**Consultation Response from KC,  
Lead Local Flood Authority**

**2025/91531 land off, Leeds Road, Heckmondwike, WF16 9DB**

**Demolition of existing semi-detached houses and associated buildings, and construction of 51 dwellings, including associated access and other associated works**

**Date Responded: 2<sup>nd</sup> September**

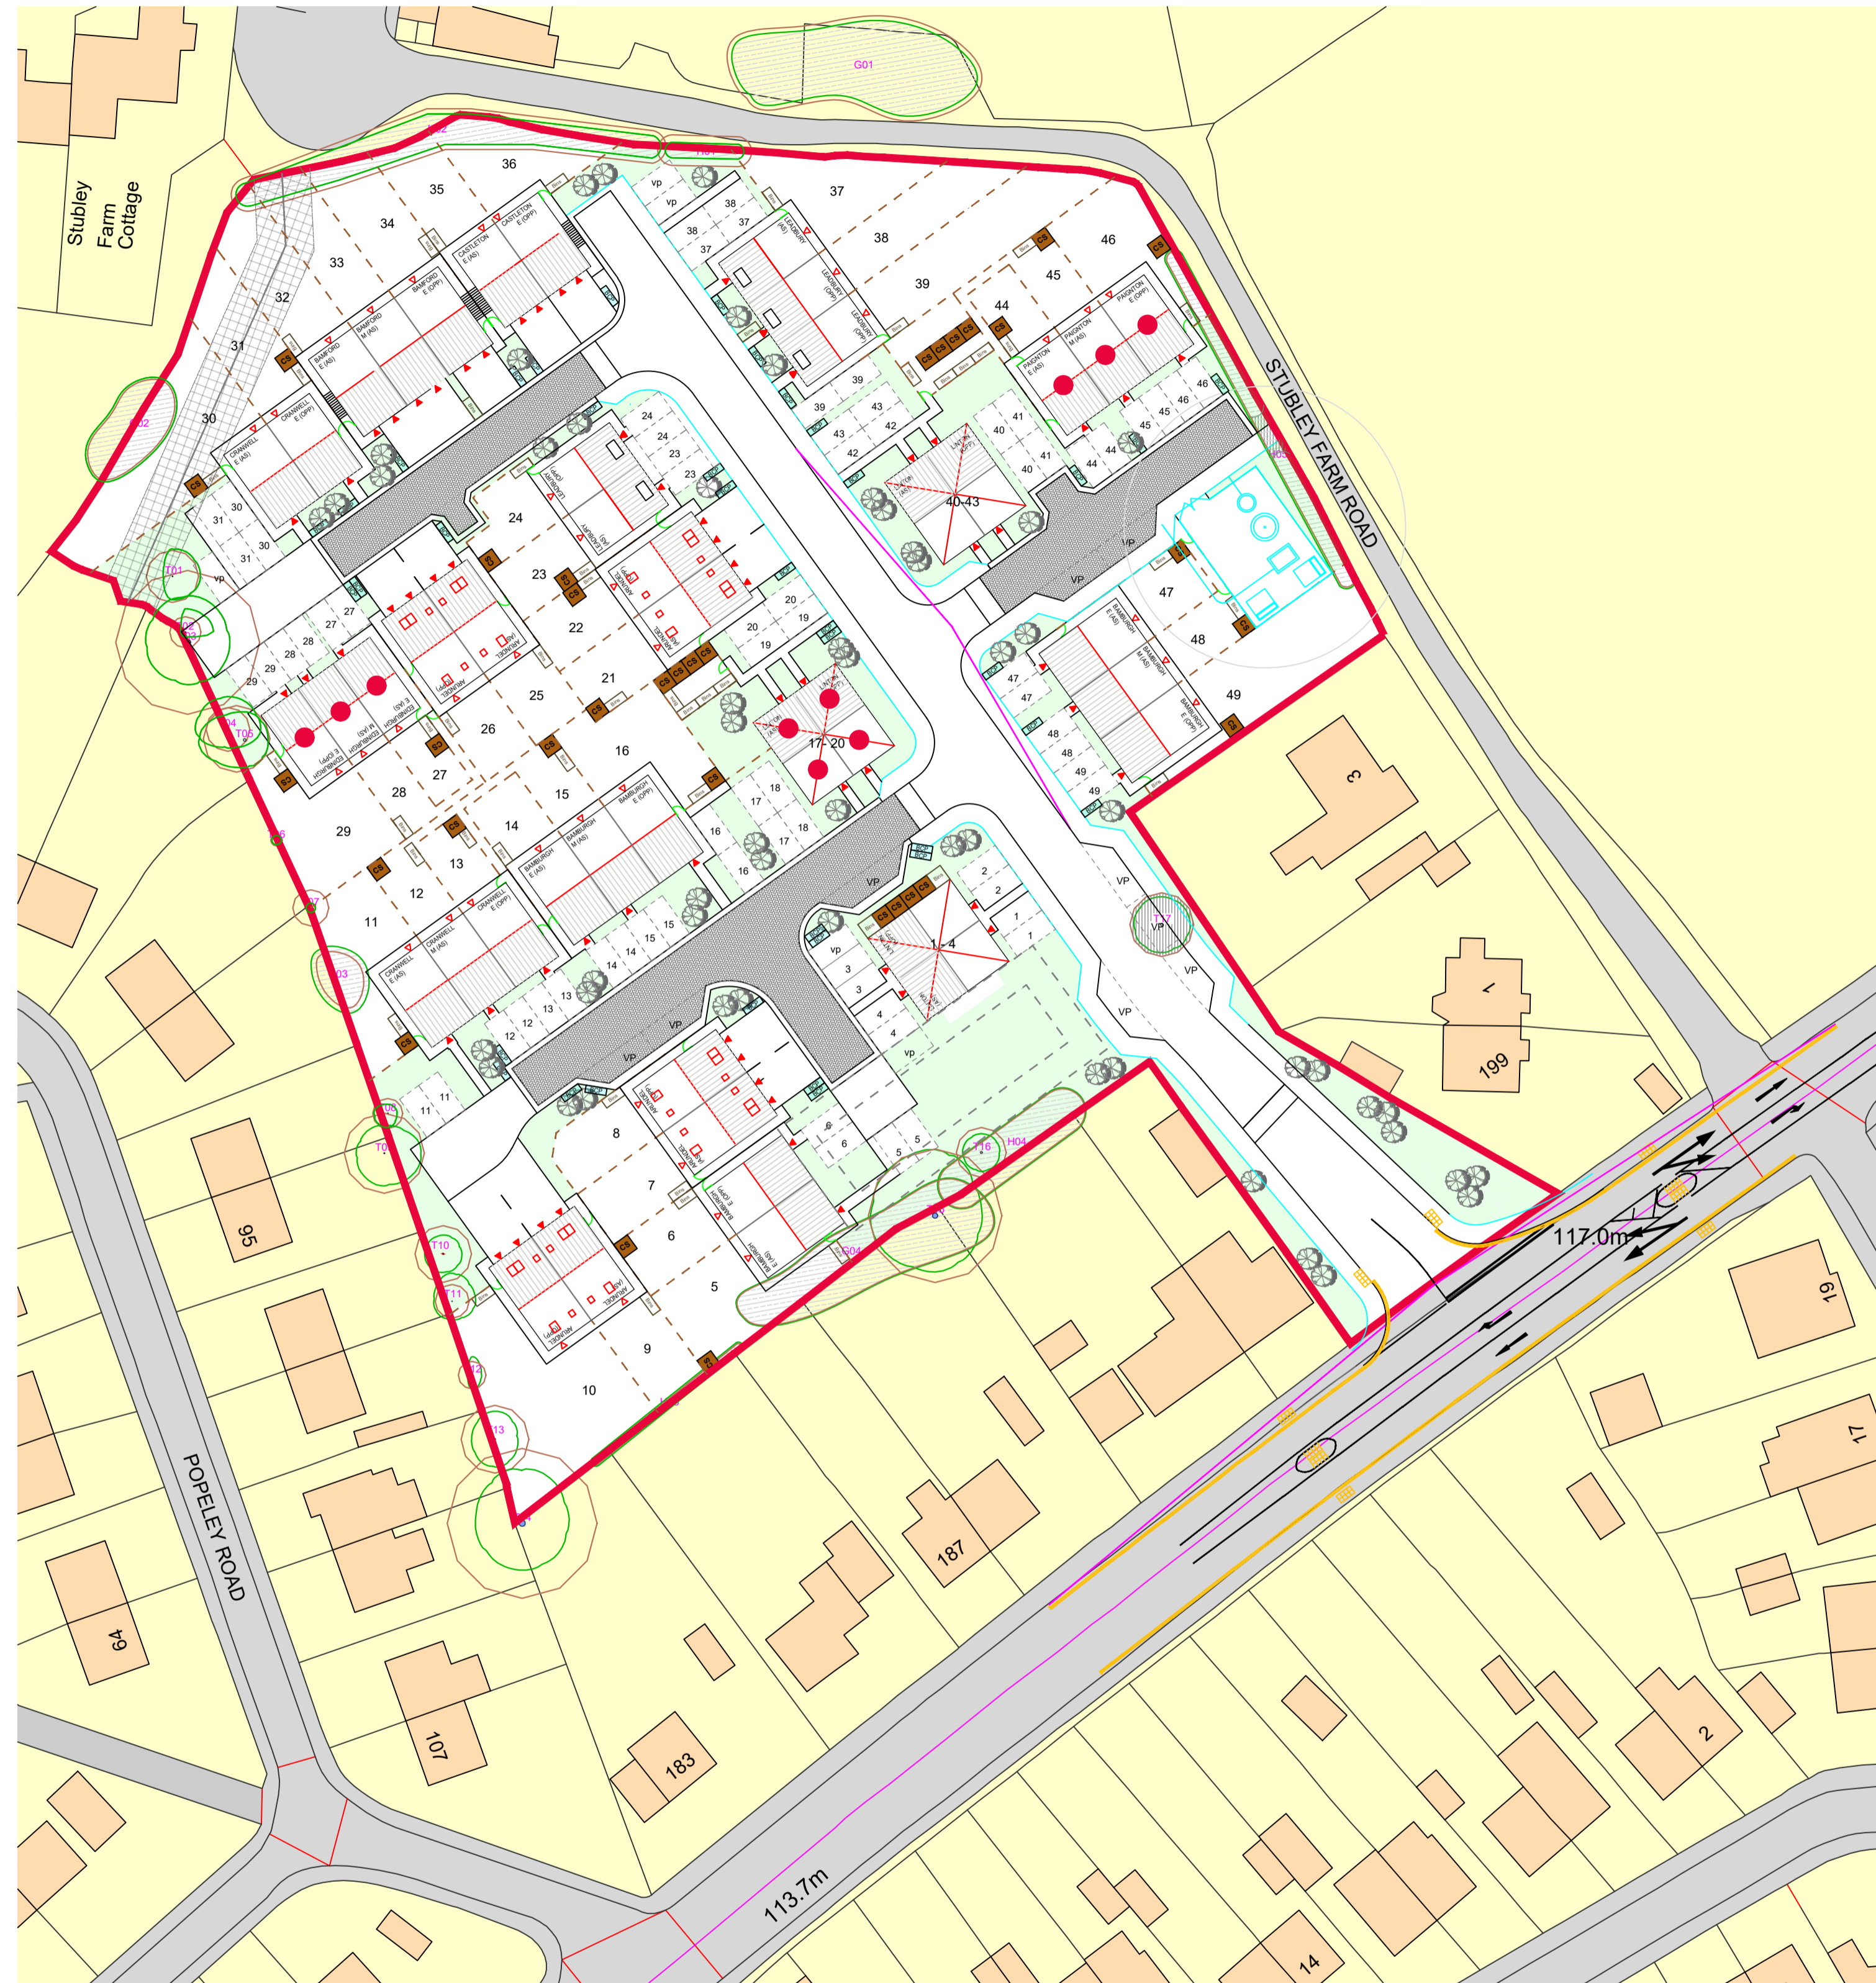
Although the land naturally falls toward existing housing, for blockage scenarios, or short duration high intensity events where surface water jumps gullies, flood routing on site had not sought to utilise the road network and public open space. As a result, there would be ponding outside properties and overspill of water through curtilage, going against design principles. We can only conclude that this was not included as a constraint in layout design submissions.
